LSC Responses to TIS Redline Comments

Sterling Ranch Filing No. 5 Traffic Impact Study (LSC #S224610) August 17, 2023

Project #
PUDSP-23-002

Figure 4
Sight Distance

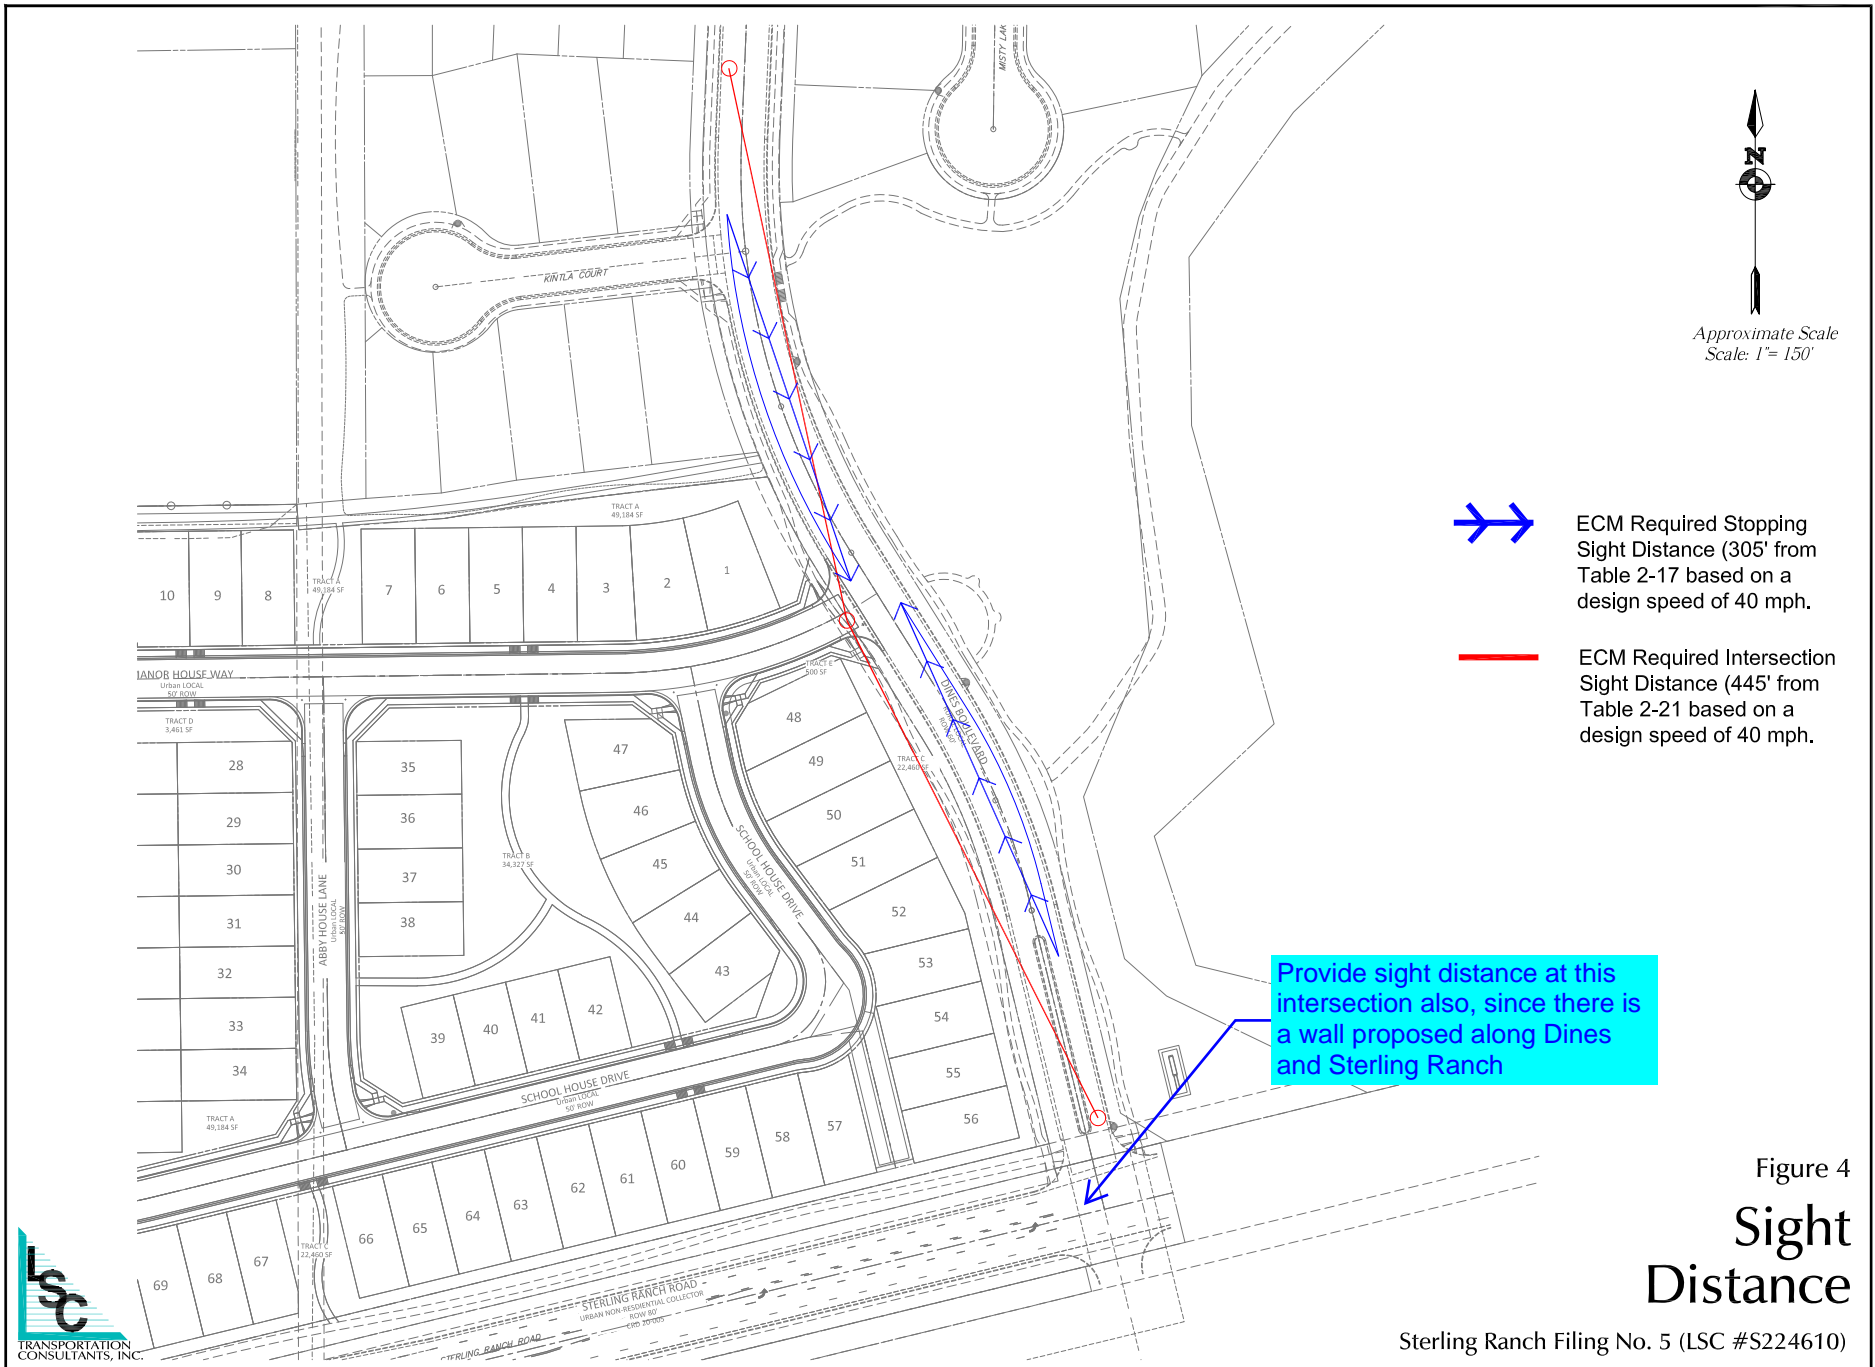
[Provide sight distance at this intersection also, since there is a wall proposed along Dines and Sterling Ranch](#)

LSC Response: The additional information has been added as requested.
